Our Ref: LU/296/19/L

Application for Listed Building Consent for Alterations, Extension or Demolition of a Listed Building

Development Listed building consent for the removal of existing rotten modern 2x2 timber studwork & modern plasterboard with skim coat plaster & replaced with 2x2 treated timber studwork & new saviot wood wool board & lime plaster & removal of existing ground floor modern plasterboard ceiling & replacement with new.

Location Friends Meeting House 23 Church Street Littlehampton

SIDE ELEVATION
West

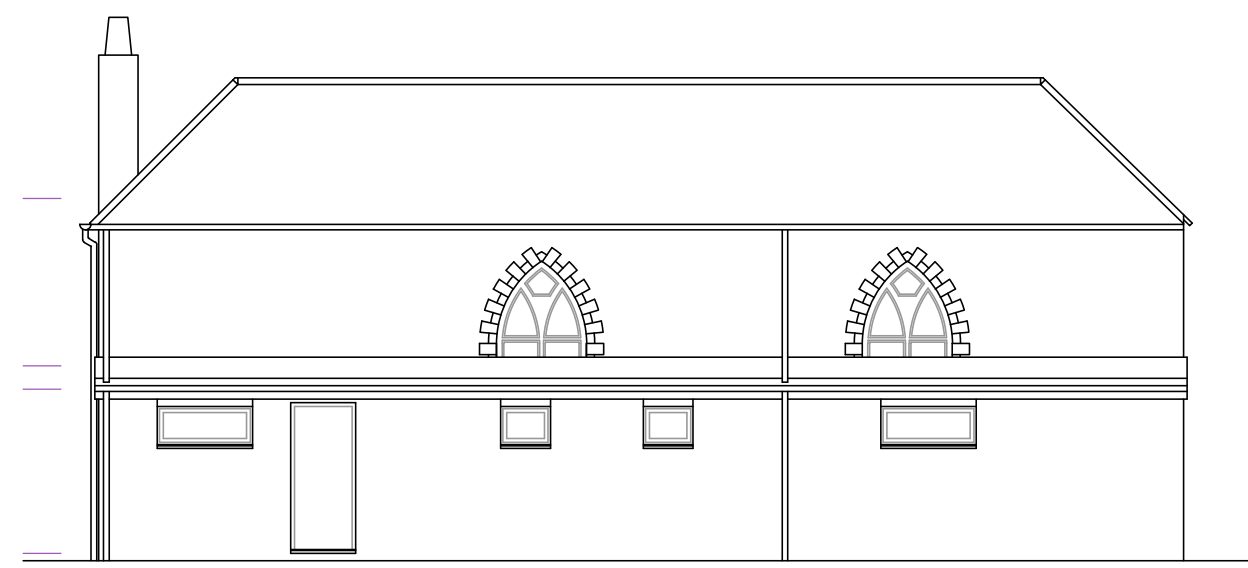
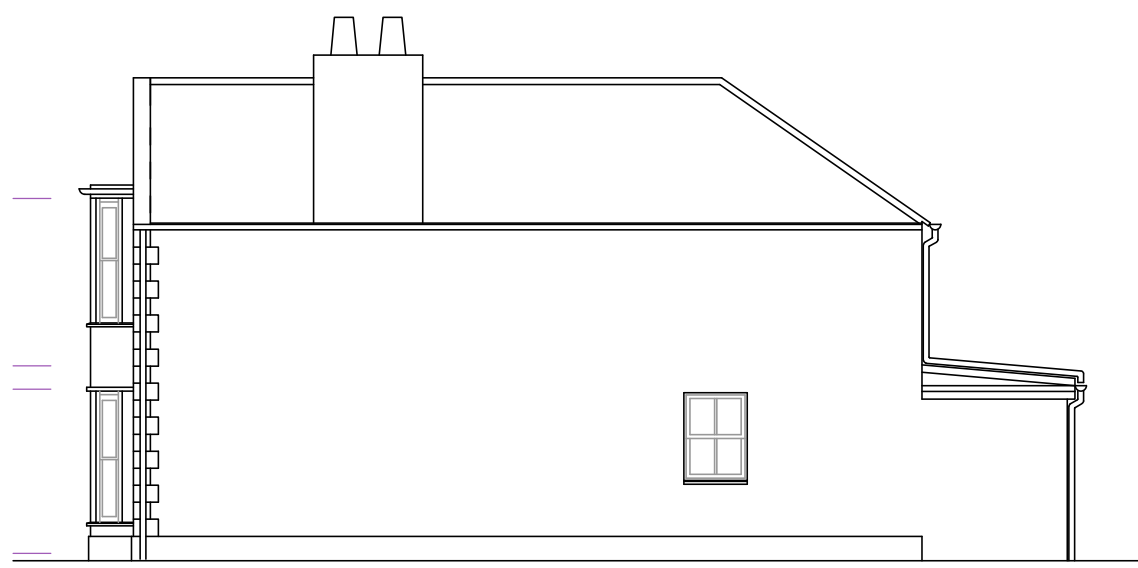
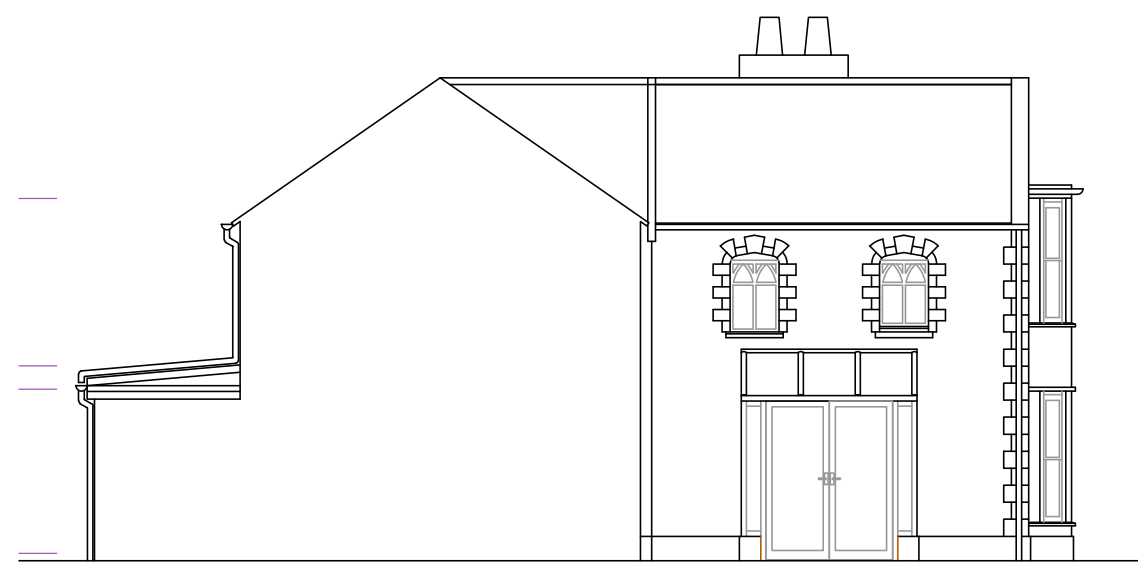
Two existing west elevations have been provided. Please amend as appropriate.
